From: Contact Centre (CRM) <contact@ribblevalley.gov.uk>
Sent: 13 August 2026 13:06
To: Planning
Subject: Planning Application Comments - 3/2026/0488 FS-Case-865196009

Planning Application Reference No.: 3/2026/0488

Address of Development: land to the rear of The Nook, Snodworth Road, Langho, BB6 8DR

I wish to object strongly to planning application 3/2026/0488 for the erection of six dwellings and associated access and landscaping on land to the rear of The Nook, Snodworth Road, Langho.

SURFACE WATER DRAINAGE STRATEGY

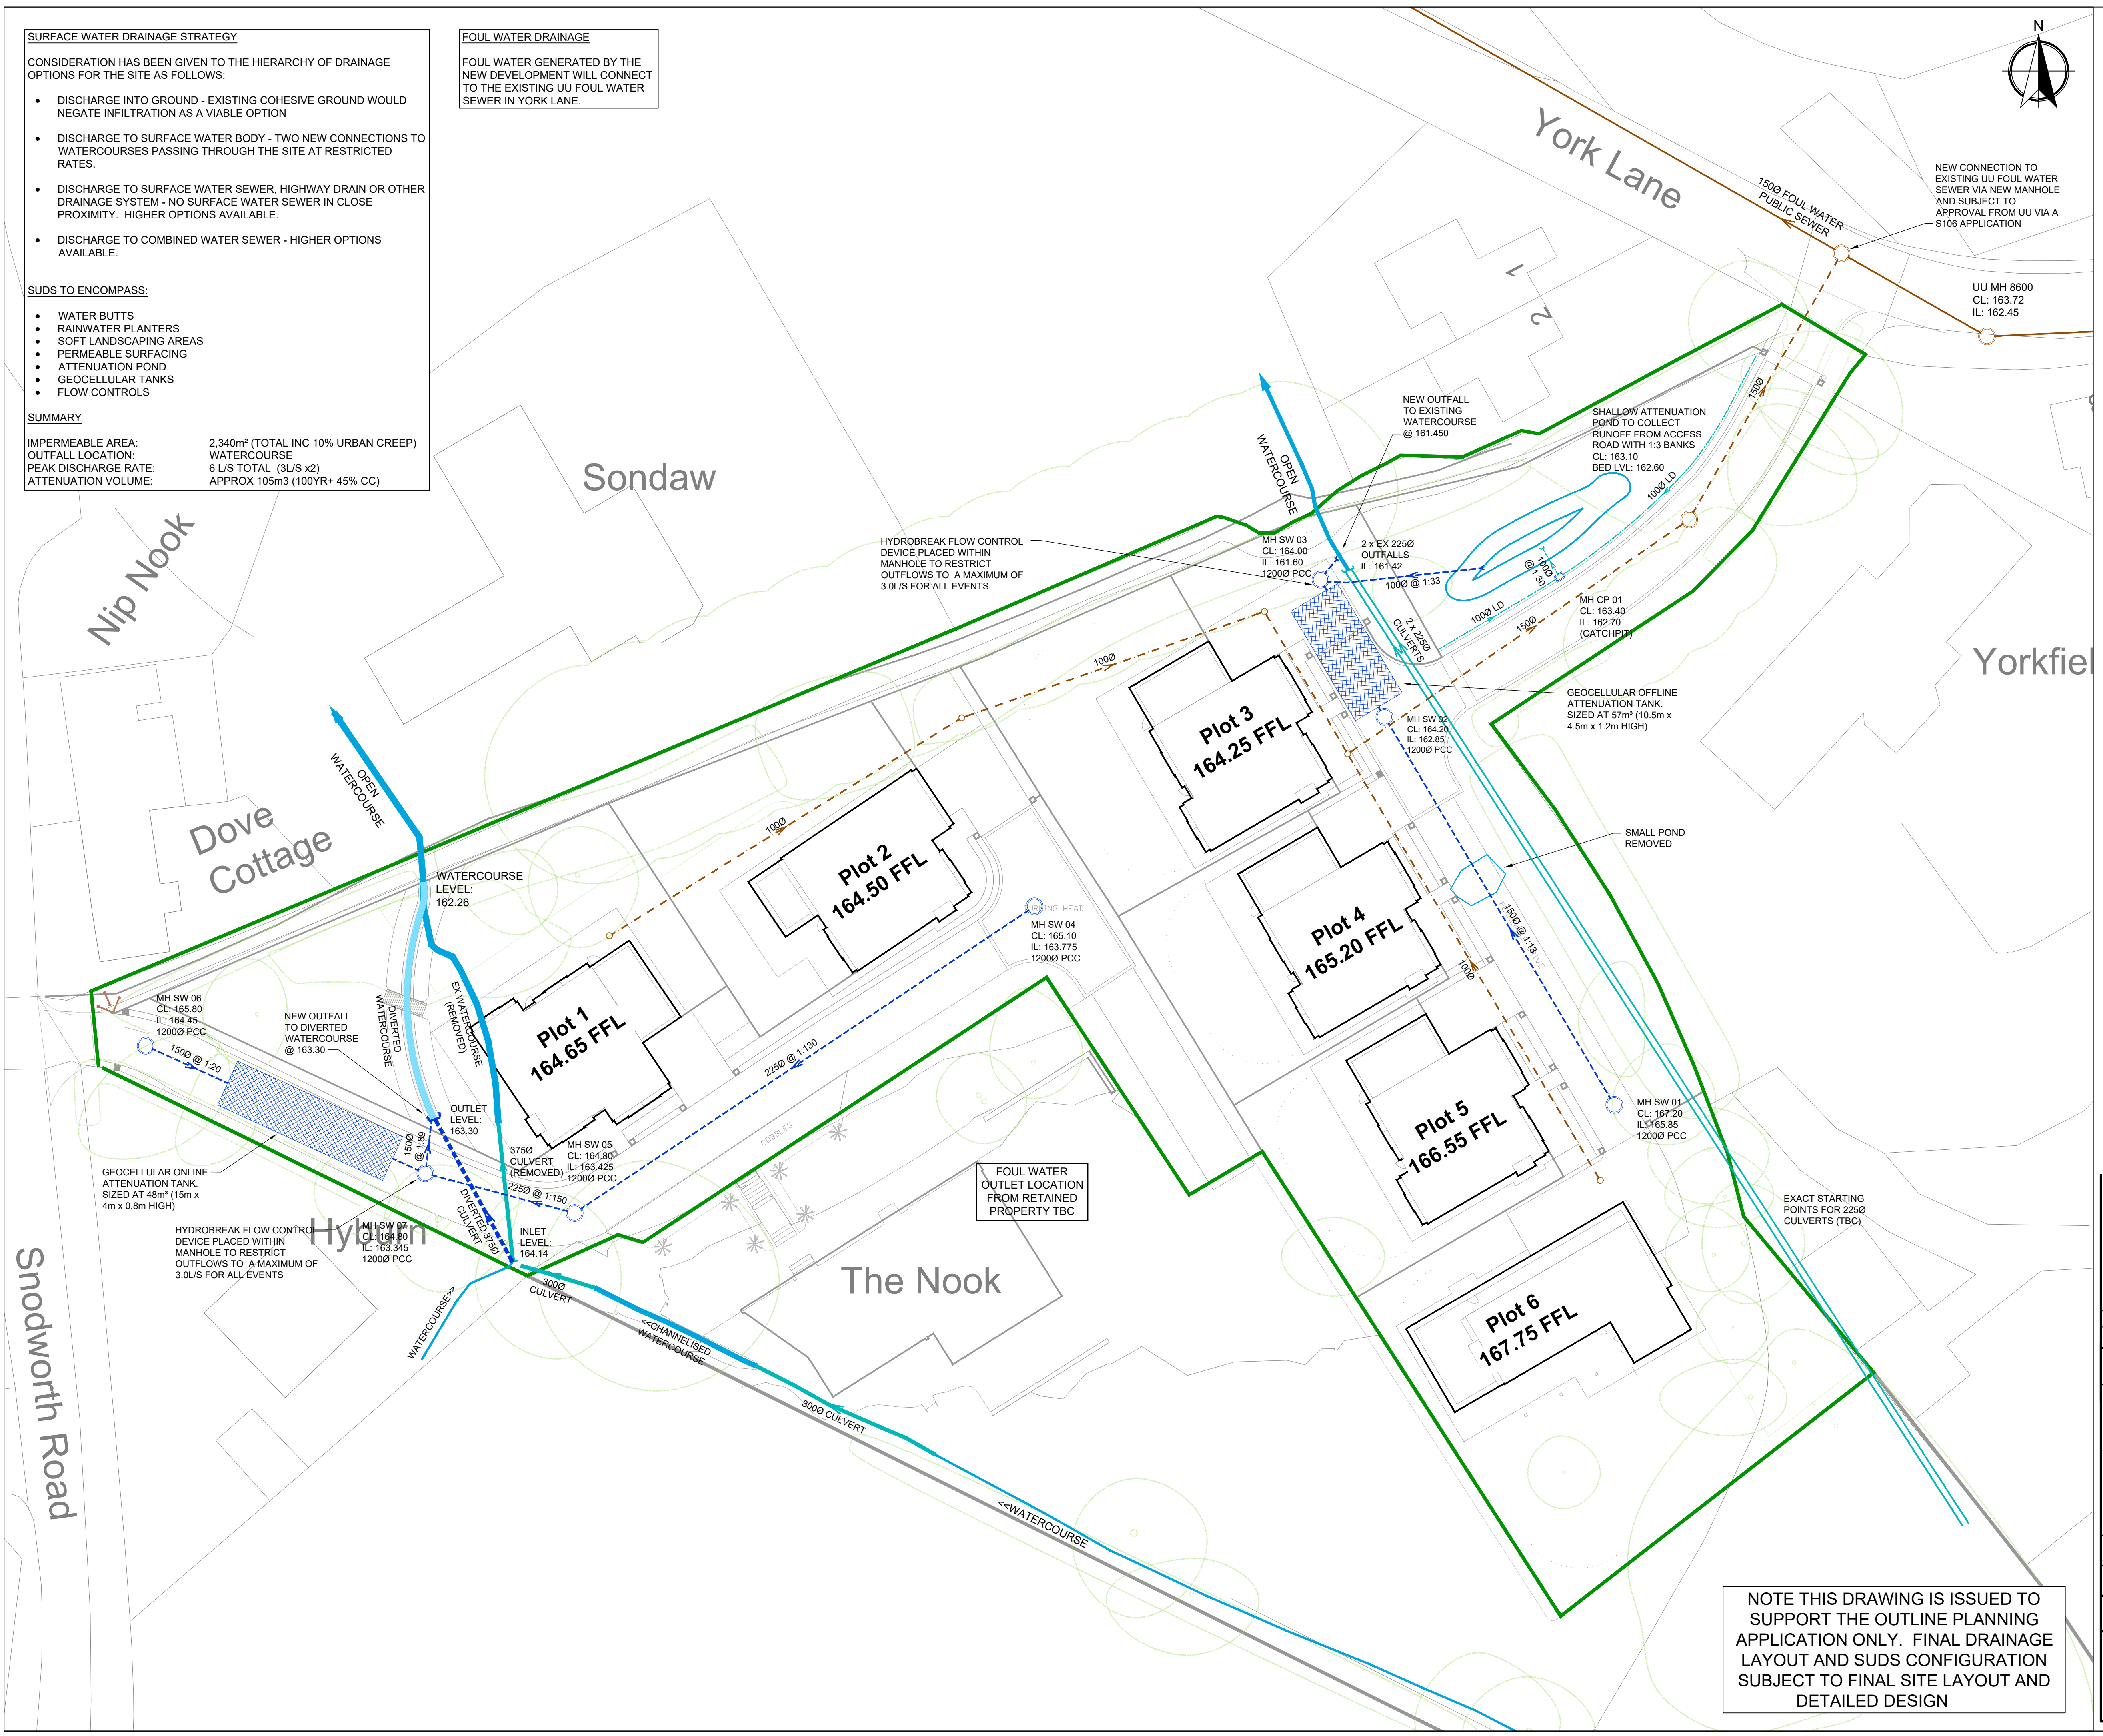
The Parish Council has reported that several watercourses run through the site and that there is a substantial pond, approximately 30 feet in diameter, which is not properly identified in the information submitted.

The applicant proposes a SuDS strategy and refers to rearranging an open watercourse. However, before permission is granted, the Council should establish the existing drainage regime and ensure that all existing watercourses, ponds and sources of surface water have been properly identified and assessed.

The Council should not assume that the submitted drainage proposals adequately address existing conditions until the actual site drainage has been independently verified.

- * existing watercourses;
- * the pond;
- * groundwater;
- * the existing water table;
- * surface-water flows;
- * the effect of development on neighbouring properties;
- * the proposed alteration or relocation of any watercourse;
- * the capacity and maintenance of proposed SuDS;
- * exceedance routes; and
- * the effect of increased impermeable surfaces.

1 | Proposed Long Section through The Nook
1 : 200

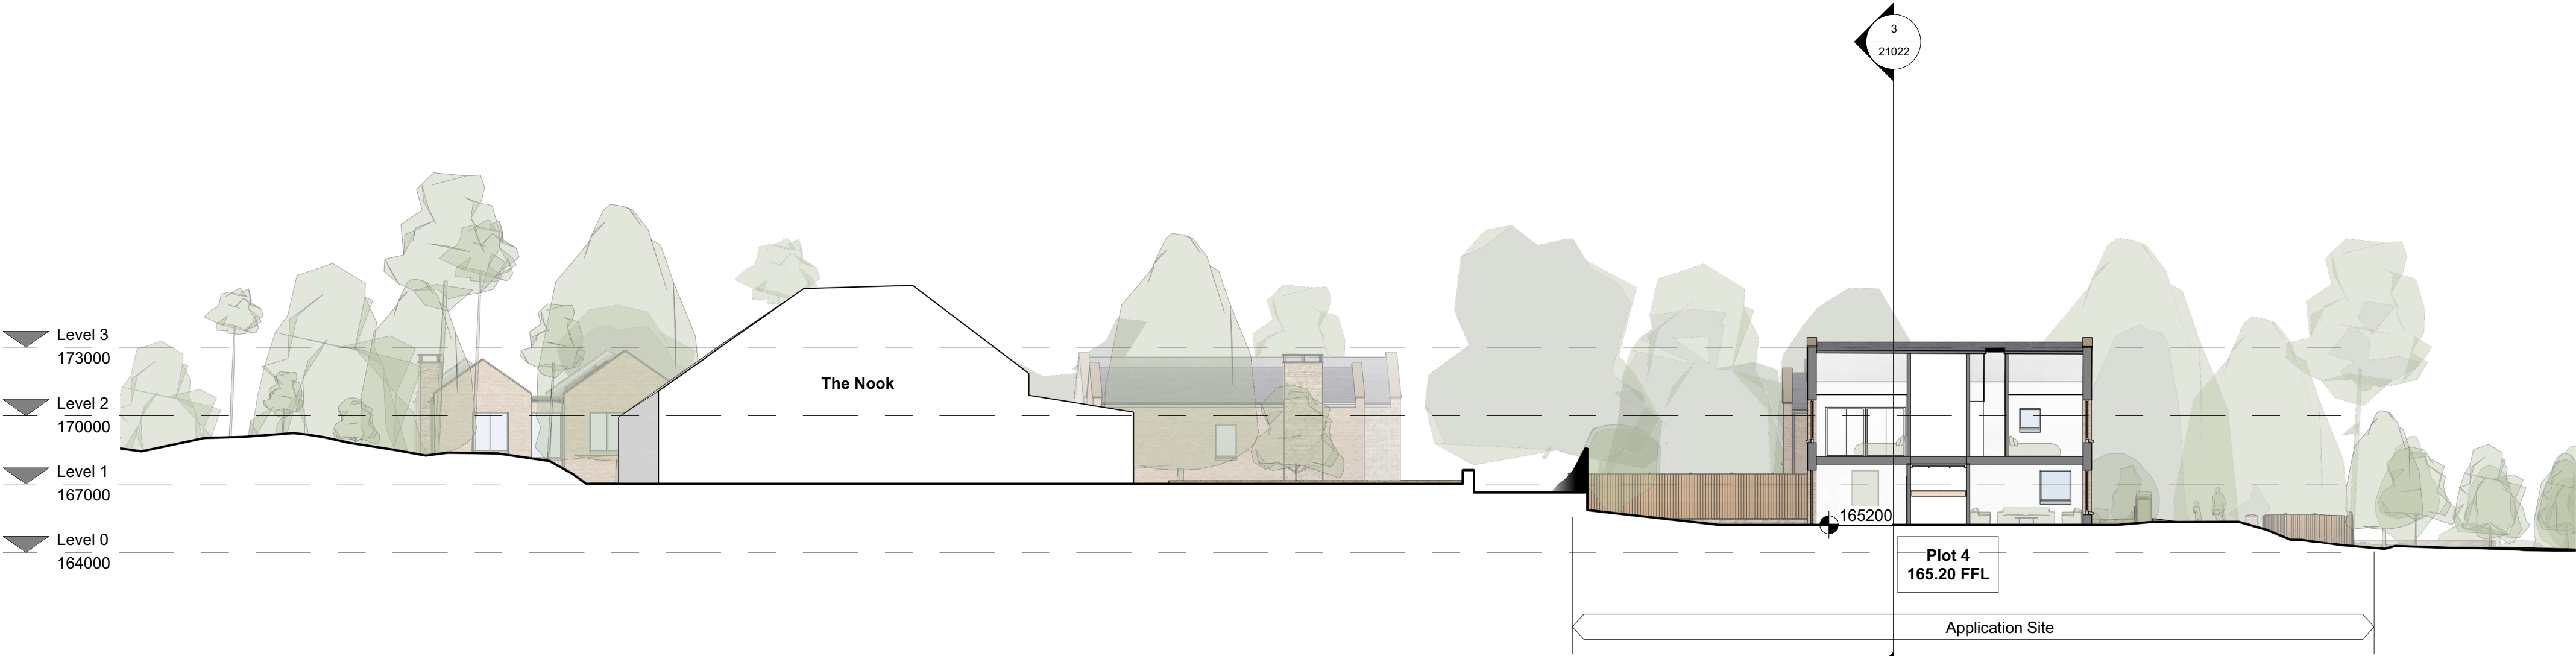
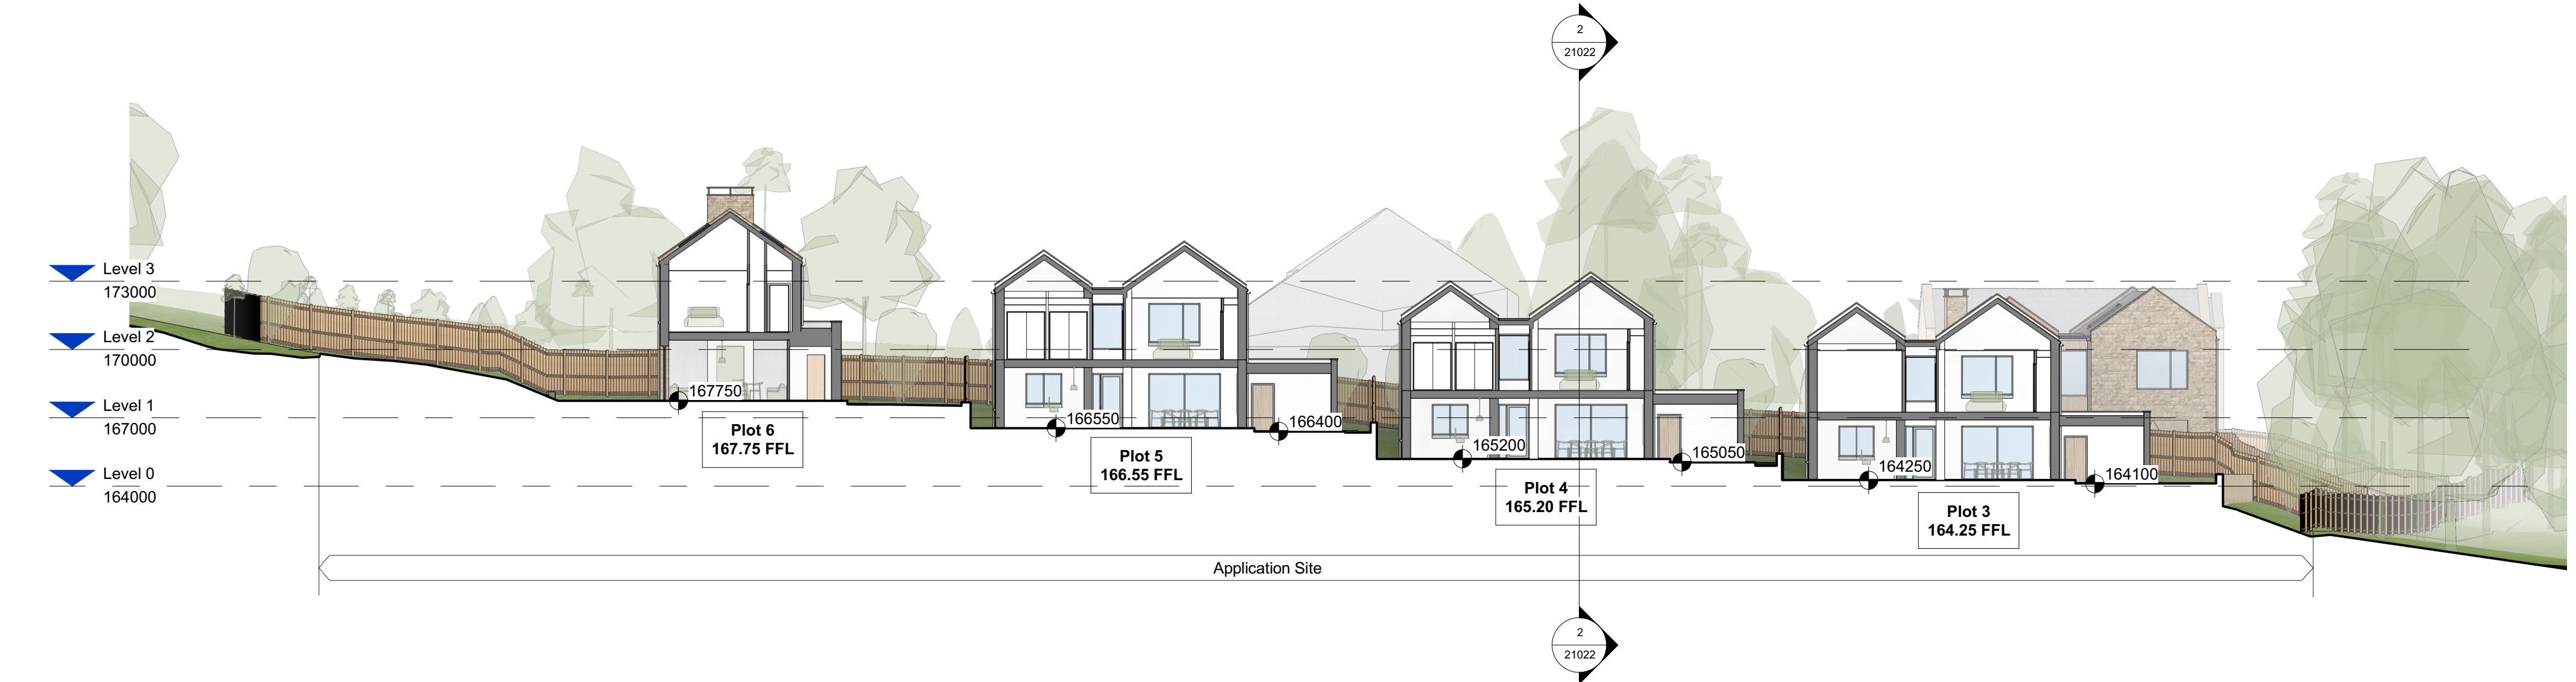
Changes in level are an important consideration because buildings positioned on rising or elevated ground can appear substantially more prominent than their footprint suggests.

The Council should therefore carefully assess the proposed finished floor levels, ground regrading, retaining structures, driveways and building heights in relation to existing neighbouring properties and public viewpoints.
